Your Ref: 000014324
Our Ref: WA/72/12/ 21-11-2012
Please ask for:
Mrs S Leeson

Revisions to previous approval WA/66/11 for the proposed refurbishment works to the Holly Tree pub including 4 no. bed & breakfast rooms

The Holly Tree Public House The Street Walberton

NORTH WEST ELEVATION AS PROPOSED

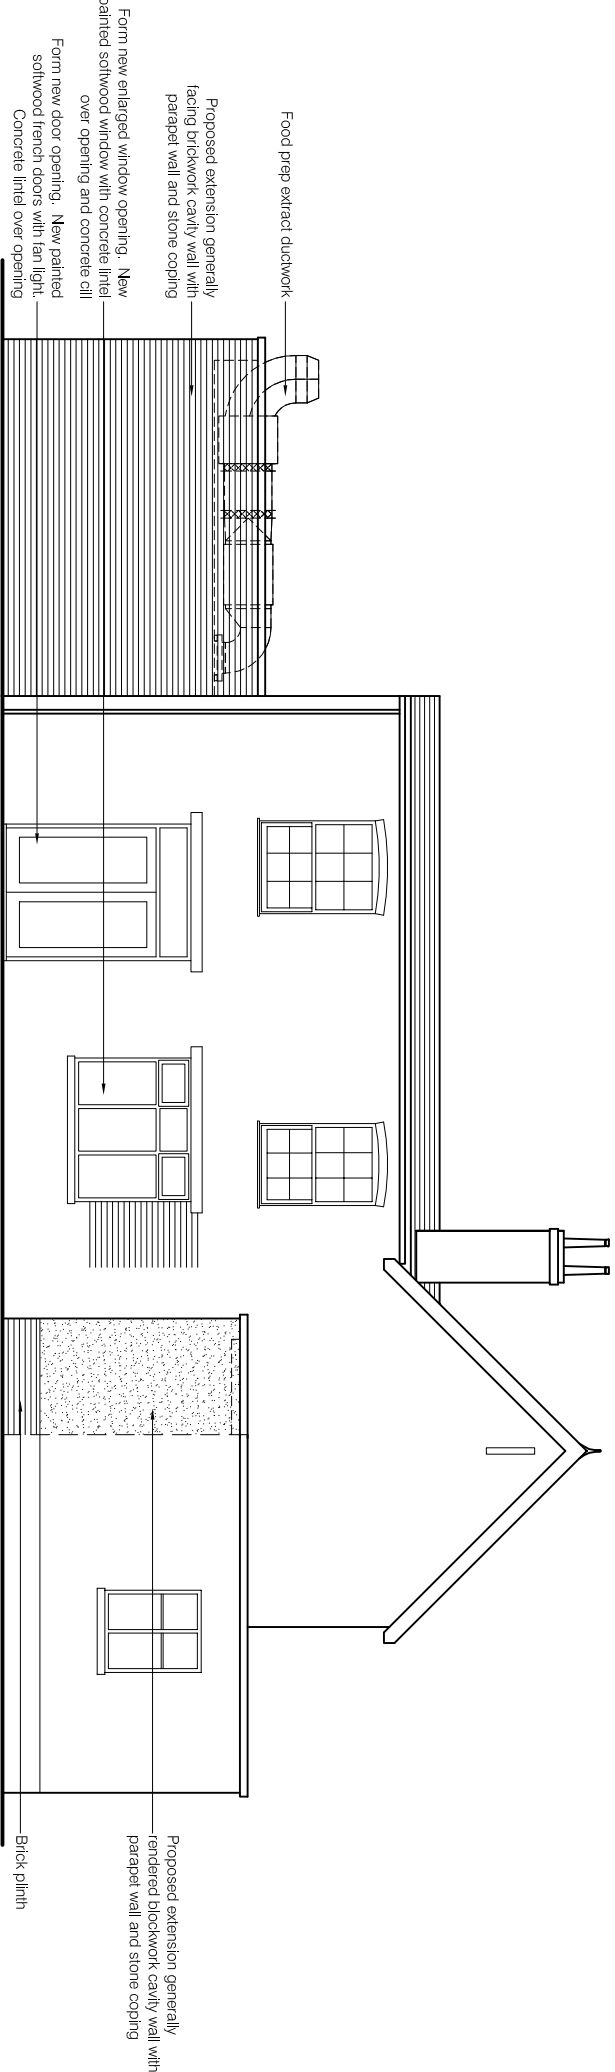
The Sussex Pub Company has an excellent local reputation and a business model that suits The Holly Tree Pub very well and one that I am delighted to support. However, in order to ensure that the new terrace on the west side of the pub does not impact on the neighbours privacy, screening provision should be included eg by heightening existing boundary wall.
